## **Application by Four Ashes Limited for an Order Granting Development Consent for the West Midlands Interchange**

### **The Examining Authority's written questions and requests for information (ExQ1)**

**Issued on 4 March 2019**

Figure 12.6 **A**

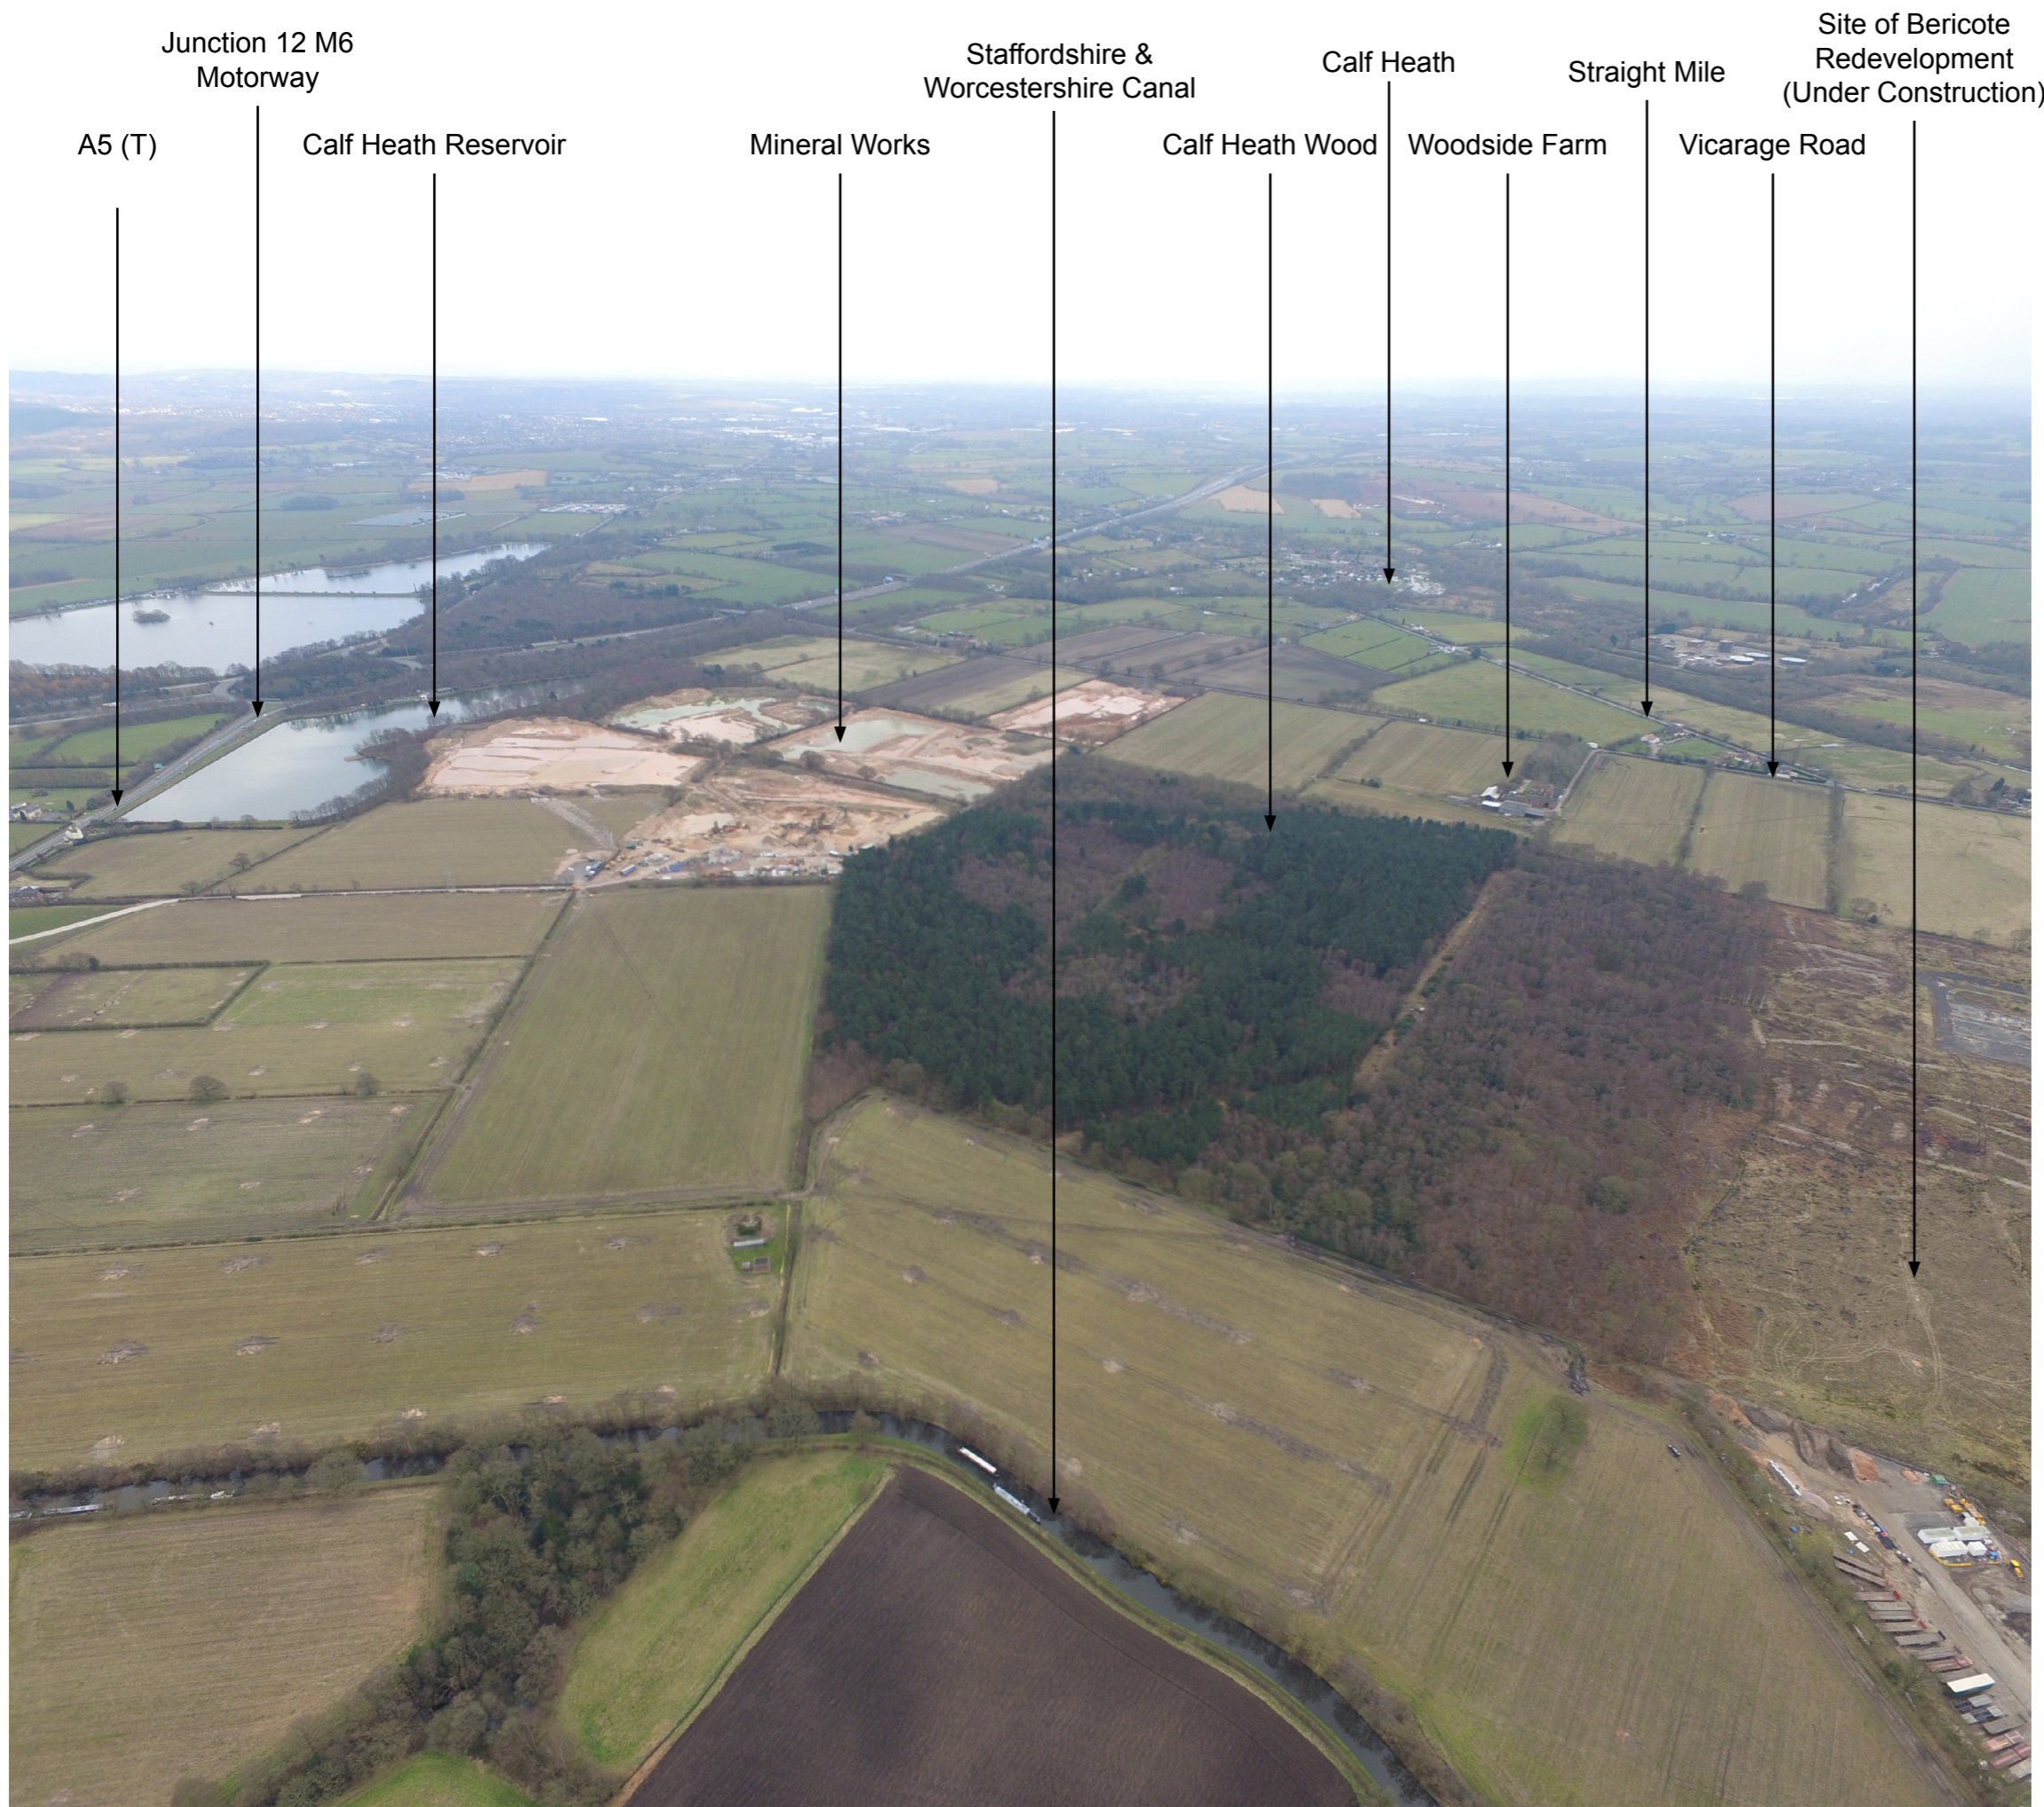
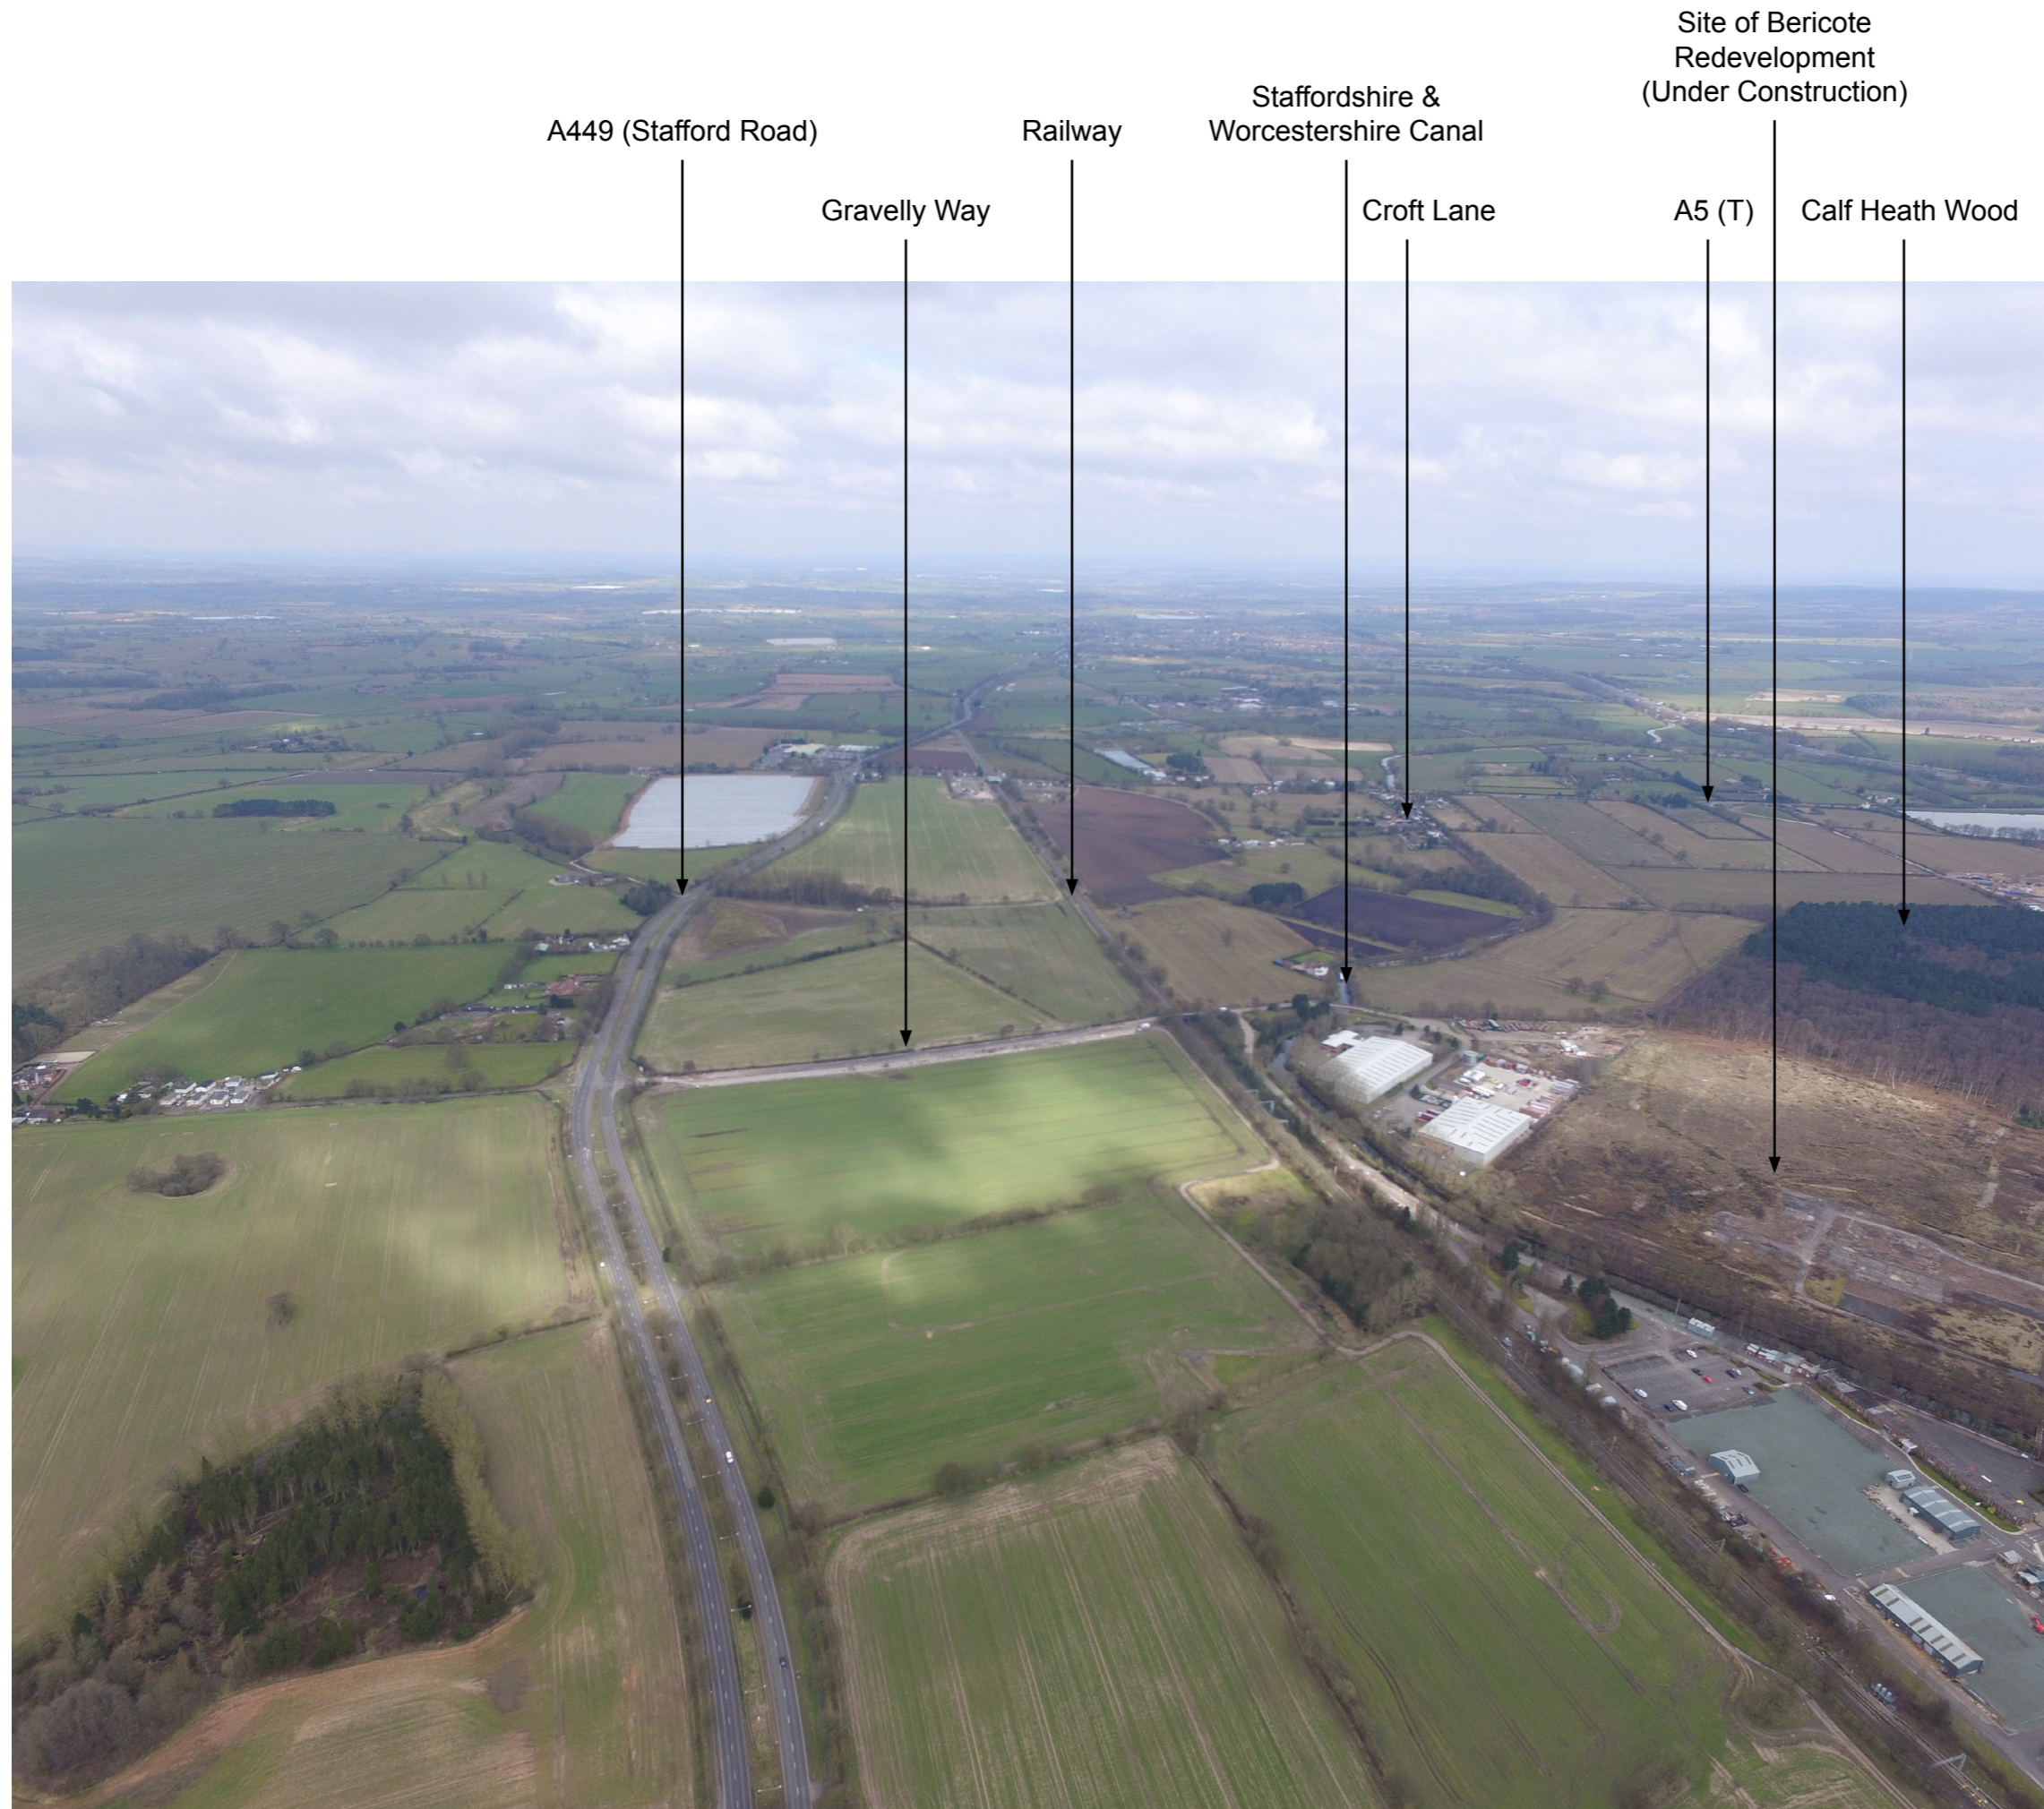
ExQ1	Question to:	Question:
1.0	<b>General and Cross-topic Questions</b>	
1.0.1	The Applicant and SSDC	<p><b>Existing Land Uses.</b>          Some of the base plans used in the submission include the notation 'Caravan Park' on land to the west of Croft Lane. This use is not evident on the aerial photographs in ES Figure 12.6 and does not appear to have been referenced or considered in the ES.</p> <p>(i) Does the use still exist and, if so, does it include any permanent residential use?</p> <p>Yes the current position is that planning permission was granted in 7.2.1961 (for 6 caravans) and 26.2.1963 for 3 additional caravans (copy enclosed of the site licence and planning permissions).</p> <p>In addition there is a planning permission in place under 18/00141/FUL for a mobile home. Copies of the 2018 permission and supporting reports can be supplied or can be viewed here - <a href="https://services.sstaffs.gov.uk/sscwebviewer">https://services.sstaffs.gov.uk/sscwebviewer</a></p> <p>Under the permission 18/00141/FUL, for retention of existing mobile home, the following condition was imposed:</p> <p><i>1. The mobile home hereby approved shall be removed from site within two months of it no longer being required to provide accommodation for the applicant's father, and shall thereafter be returned to grassland.</i></p> <p>In addition there is an extant site licence for 9 caravans to be stationed (in accordance with section 3 of the Caravan Sites &amp; Control of Development Act</p>

<p>1960).</p> <p>(ii) If not, is there a planning permission in place or other means by which such a use could be resumed or resurrected in this location and could this include any permanent residential use?</p> <p>See above</p>
